KITTITAS COUNTY

DEPARTMENT OF PUBLIC WORKS

TO: All Staff
FROM: Public Works Plan Review Team
DATE: November 17, 2025
SUBJECT: LPF-25-00006 Wildcat Plat

KITTITAS COUNTY		WASHINGTON	
DWN BY	DATE	JOB NO.	
JCR/GW/DLP	10/2025	062984	
CHKD BY	SCALE	SHEET	
DLP	1" = 200'	2 OF 3

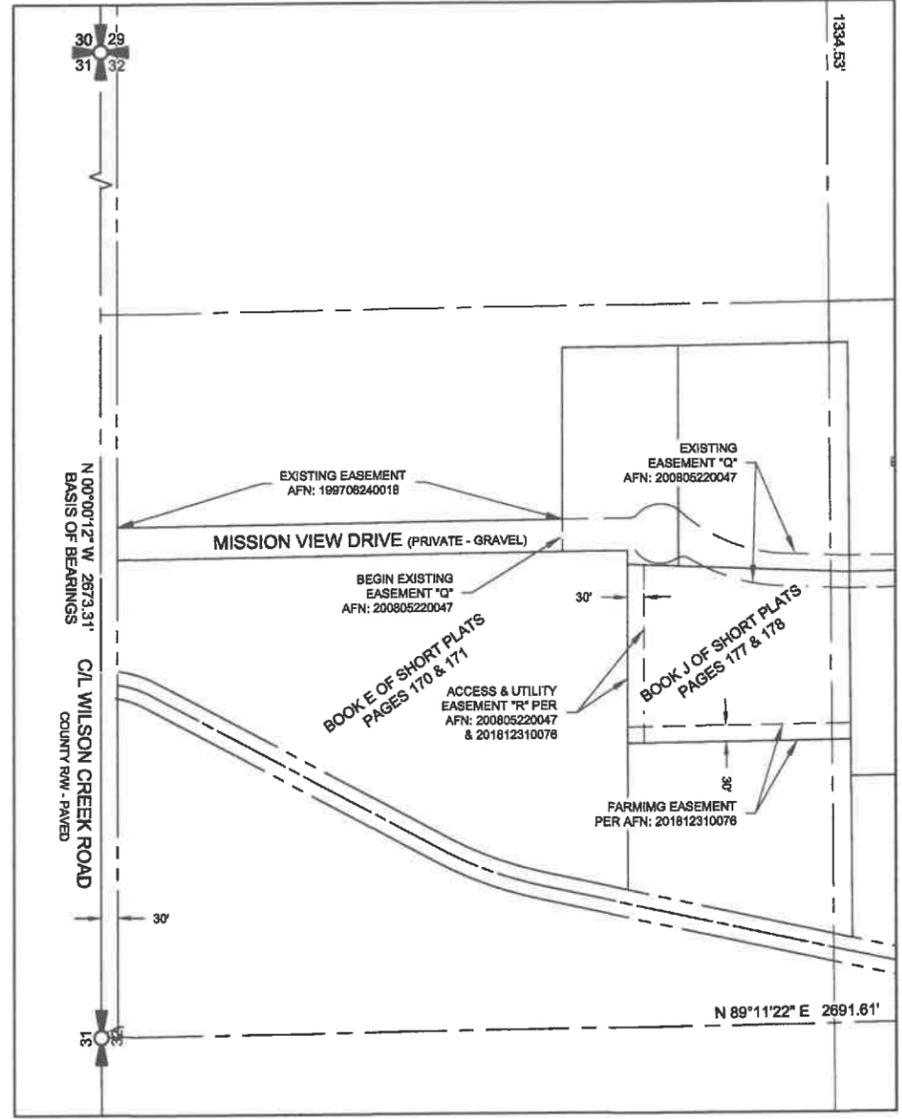
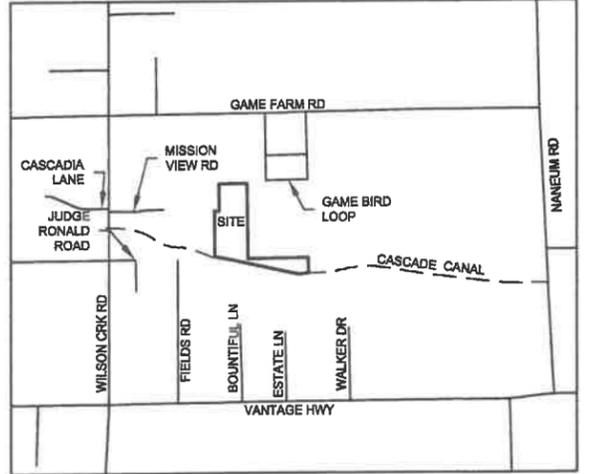
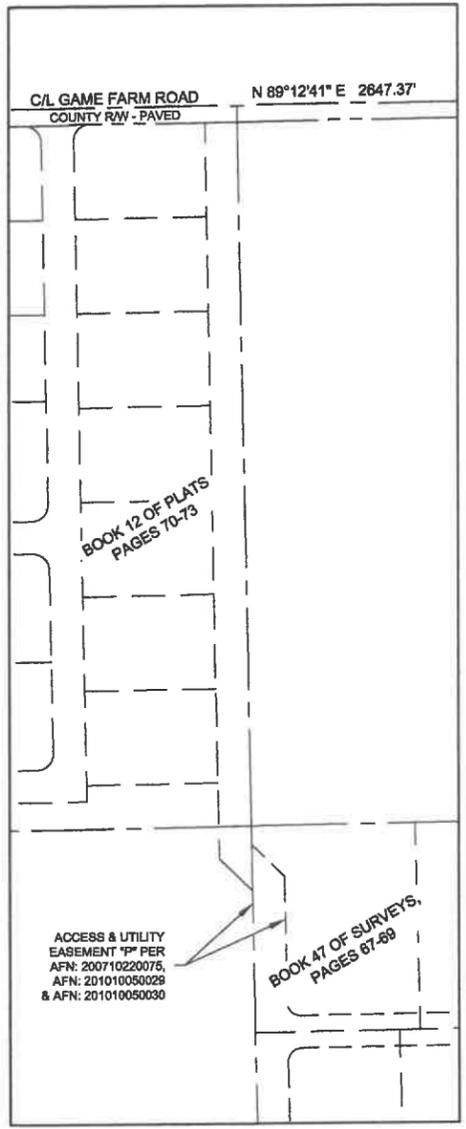
SURVEY	1. Relating the linework between Sheet 1 and Sheet 3 is difficult. This could be made easier by labelling the center of section OR labelling the SW1/4 of NE1/4 on Sheet 1 (APN 958408). 2. The N-S midline of section is shown as S00°43'17"E on sheet 3 and S00°43'15"E on sheet 1. (JT) <i>See attached survey. Pending final departmental comments and approval, the applicant will submit the final plat on mylar.</i>
TRANSPORTATION CONCURRENCY	A concurrency evaluation and determination shall be required for all development applications in which the proposed development is projected to have an impact upon the transportation corridor or intersection. Developments generating 41 or fewer daily trips are exempt from the TIA and concurrency evaluation requirements. (KAH) <i>See attached email in Exhibit A. As this plat is vested under the regulations and conditions in effect at the time of original submission, a concurrency evaluation is not required for approval.</i>
